An
Coimisiún
Pleanála

Inspector's Report

ACP-324153-26

LRD: Demolition of 10 agricultural buildings /sheds and the construction of a residential development of 140 no. residential apartment units. Development is situated within the curtilage of Bessborough House which is a Protected Structure (Ref: RPS 490). An EIAR and a NIS are included.

Figure 01: Relationship between Block C and Bessborough House

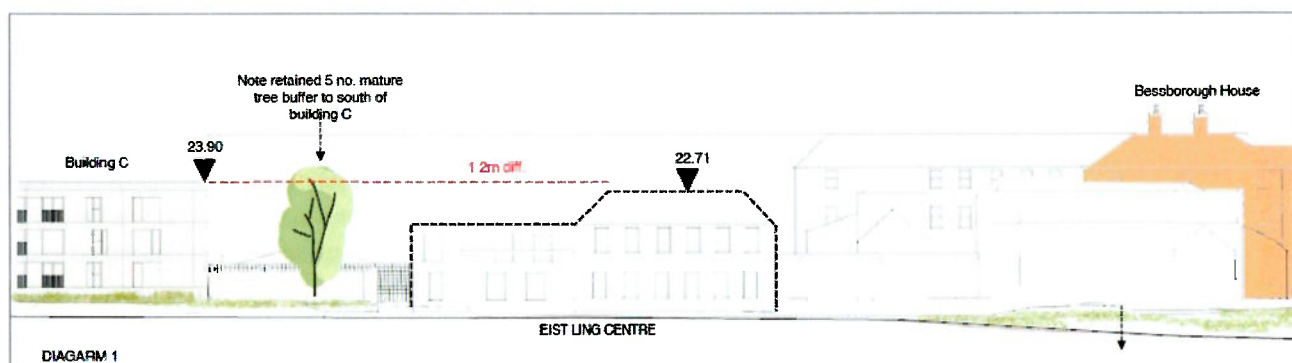
Omit Block C, its associated access road/ car park and to submit revised plans/ details demonstrating this.

The Planning report reflects the decision to grant permission subject to conditions. The report identifies a concern with Block C in that it would have a negative impact on the historical setting of Bessborough House and associated grounds/ garden. This issue was raised by the Conservation Officer, Senior Parks and Landscape Officer and the Biodiversity Officer. It is therefore considered appropriate that Block C and its associated car parking/ access road be omitted. The development, otherwise, was considered to be acceptable, would provide for sustainable residential densities and no issues of concern were raised through assessment of the submitted EIAR and supporting documentation.

- Conservation Report: No objection subject to recommended conditions. These include the omission of Block C and the reduction in height of Blocks D and E by one storey each.
